Application by Morecambe Offshore Wind Limited for Morecambe Offshore Windfarm Generation Assets

The Examining Authority's additional written questions and requests for information (ExQ3)

Issued on 25 March 2025

LEGEND

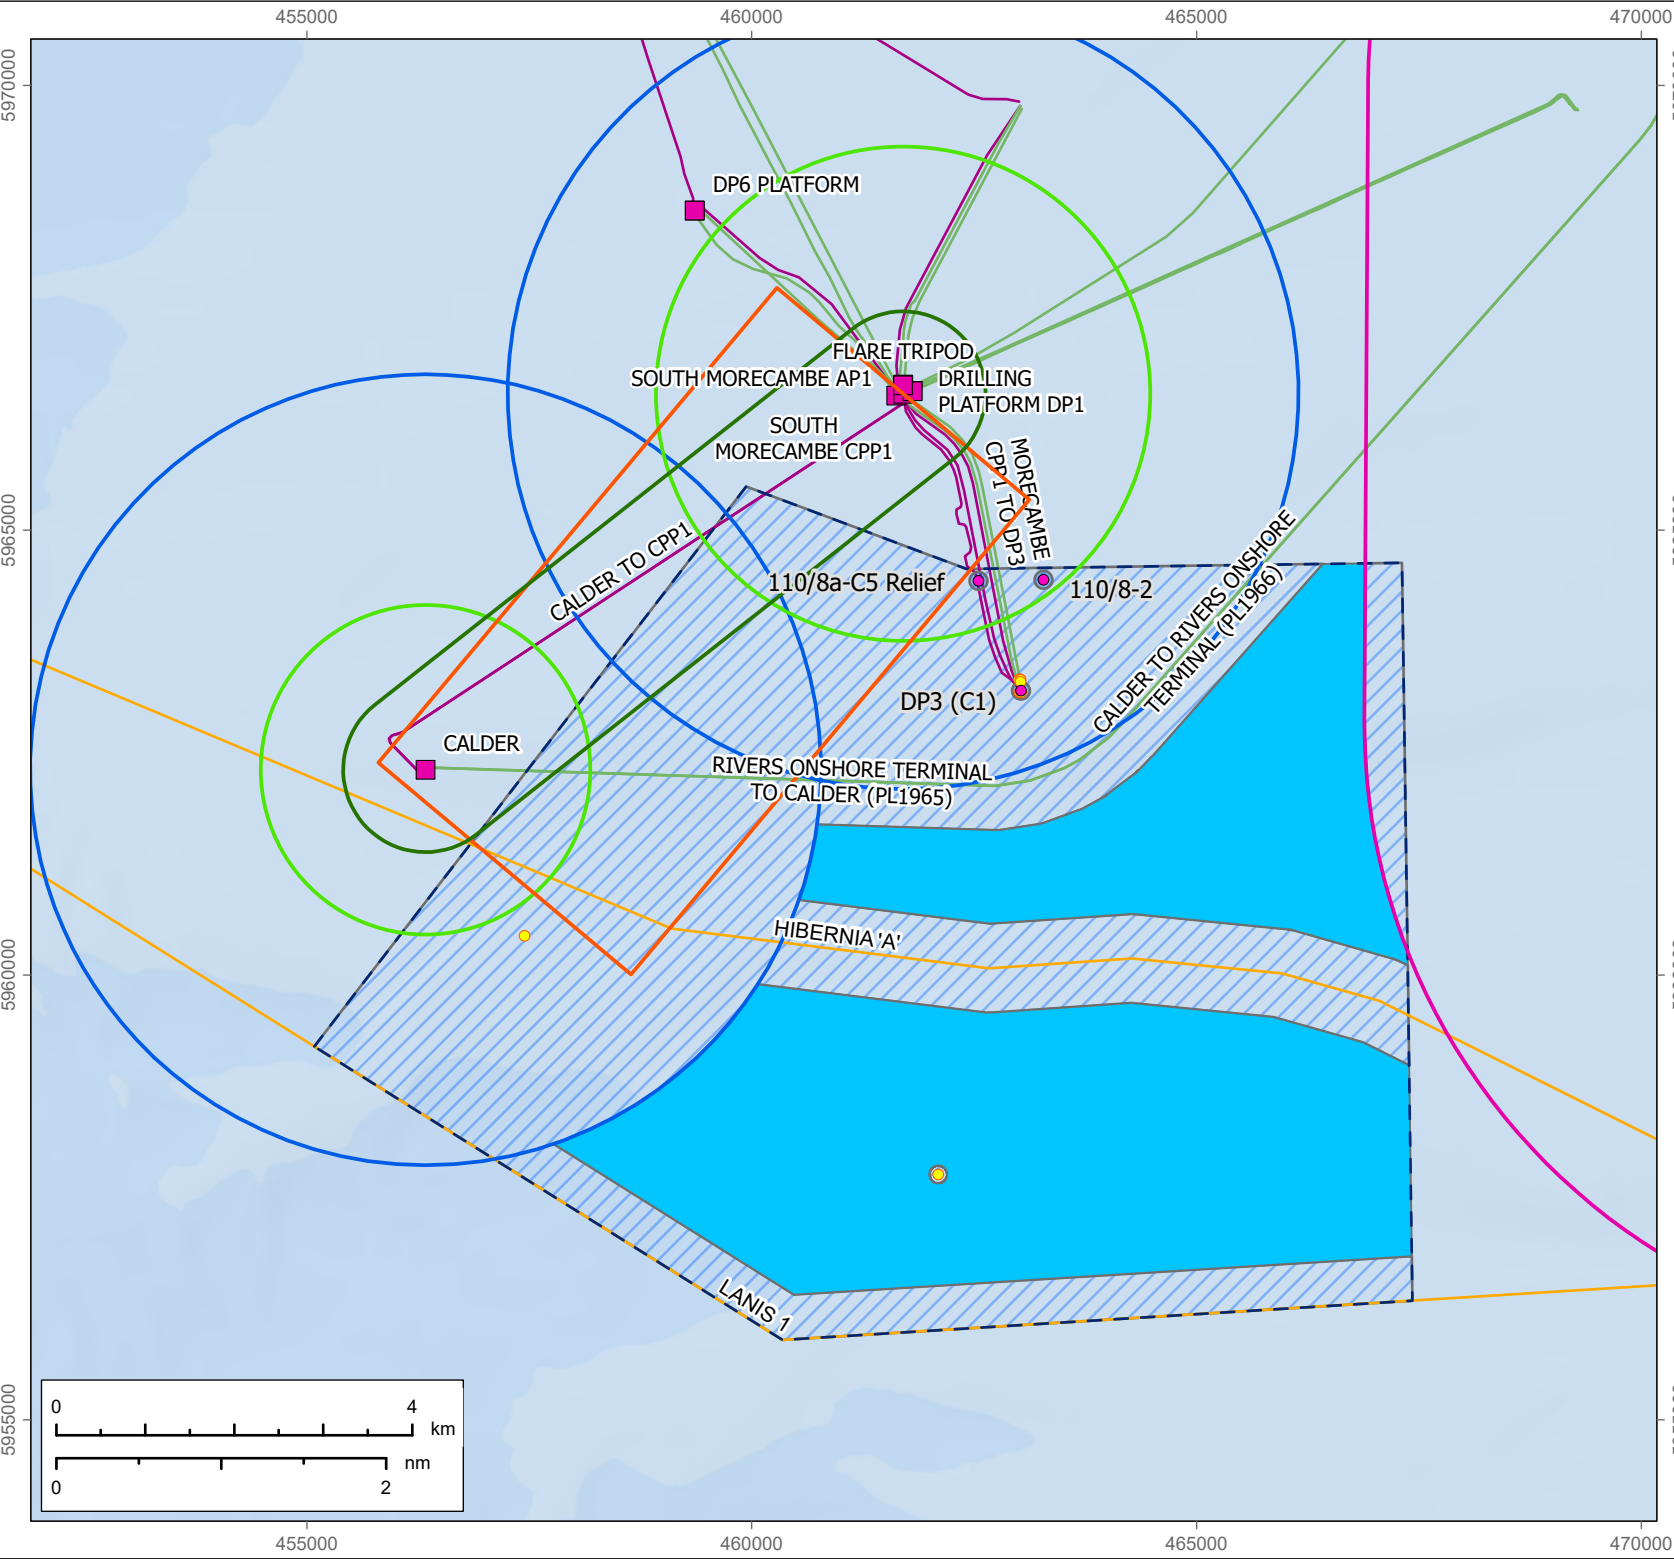
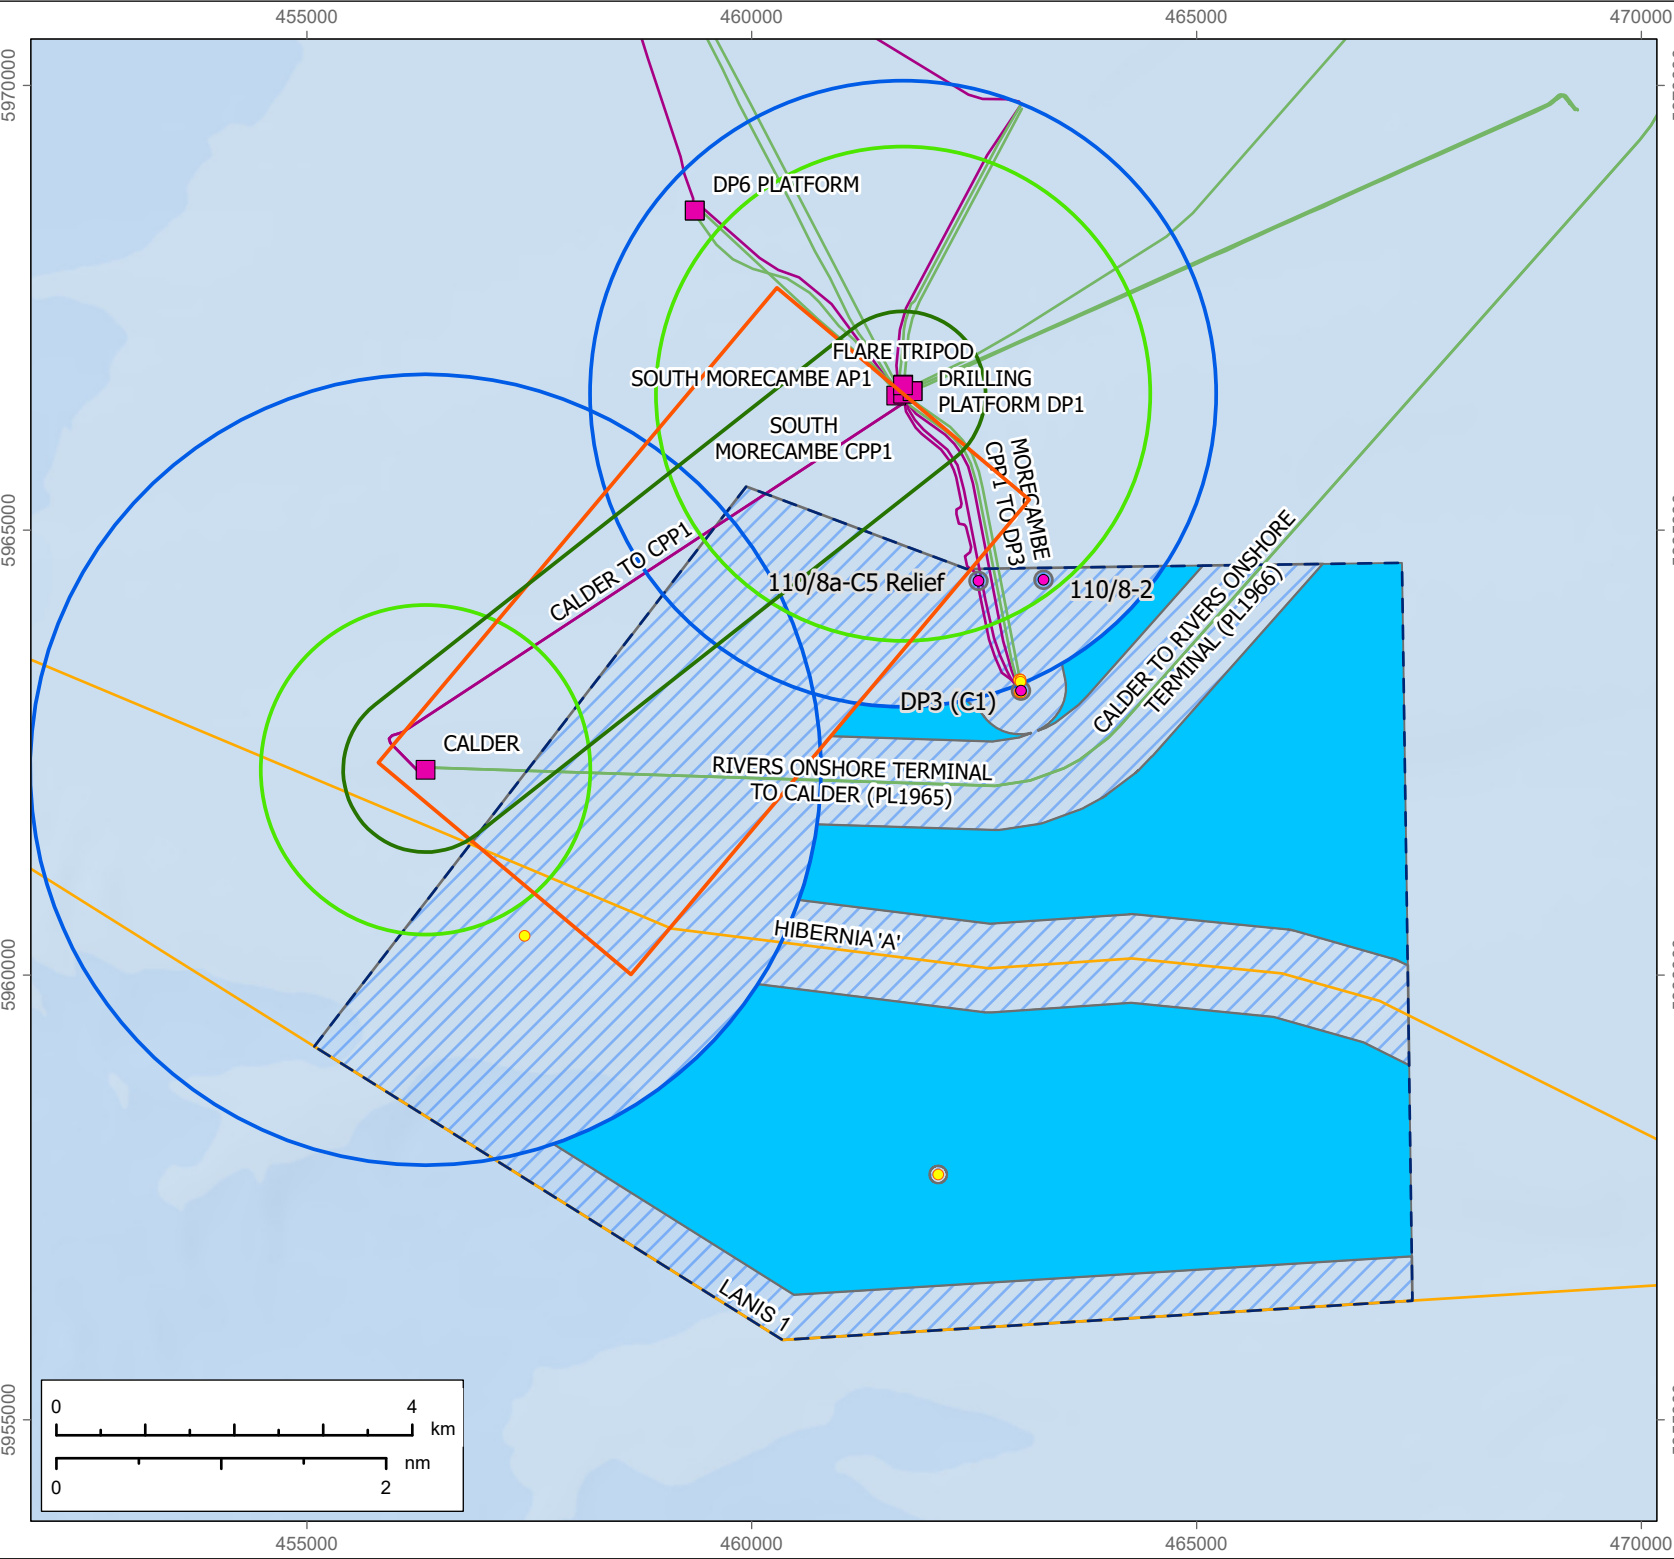
ExQ3	Question to:	Question:										
3GEN3.	The applicant	<p>Liverpool Bay SPA and Oil and Gas Platform Buffers</p> <p>Whilst the ExA notes the caveats stated in the applicant’s response to ExQ2HRA6 at D5 [REP5-070], to further demonstrate and support the applicant’s position:</p> <p>a) please can the applicant provide individual plans to demonstrate the impact that each of the incrementally smaller buffers from the original Liverpool Bay SPA would have on the layout and number of WTGs that could be accommodated within the site (i.e. 10km, 9km, 8km, 7km and so no buffer associated with the SPA affects the site) - with all other existing buffers/ corridors as shown on [REP5-007] unchanged.</p> <p>b) in Spirit Energy’s response to ExQ2CAR5 at D5 [REP5-090] it advises a buffer distance of 1.9nm is the minimum acceptable requirement for safe landing and take-off in daytime VMC and for night VMC this distance would be 2.4nm. In light of this could the applicant provide plans for each alternative SPA buffer scenario in (a) plus each of the increased buffer scenarios from the Calder and CCP1 platforms as set out in the following table.</p>

<table><tr><th><u>CPP1 WTG and OSP Aviation Buffer</u></th><th><u>Calder WTG and OSP Buffer</u></th></tr><tr><td>1.9nm</td><td>2.4nm</td></tr></table>

<p>c) any additional comments or further information the applicant wishes to provide on the implications of each of the above scenarios (noting the applicant’s previous response [REP5-070], EXQ2HRA3 and 2HRA6].</p> <p>The ExA is seeking a complete set of alternative scenarios shown on plans, so that, whatever the SoS may determine, if they felt it was appropriate they could include the relevant plan within any final DCO without having to revert to the applicant for that plan. Each should therefore have a different drawing number.</p>	<u>CPP1 WTG and OSP Aviation Buffer</u>	<u>Calder WTG and OSP Buffer</u>	1.9nm	1.9nm	2.4nm	1.9nm	1.9nm	2.4nm	2.4nm	2.4nm
<u>CPP1 WTG and OSP Aviation Buffer</u>	<u>Calder WTG and OSP Buffer</u>											
1.9nm	1.9nm											
2.4nm	1.9nm											
1.9nm	2.4nm											
2.4nm	2.4nm											
3GEN4.	The applicant	<p>Design Statement - Cabling</p> <p>Could the applicant please explain why (former) provision DC15 relating to use of the most direct/ efficient cabling route to minimise cutting has been deleted from the post-consent design code in Table 6.1 of the Design Statement [REP5-008] and [REP5-009].</p>
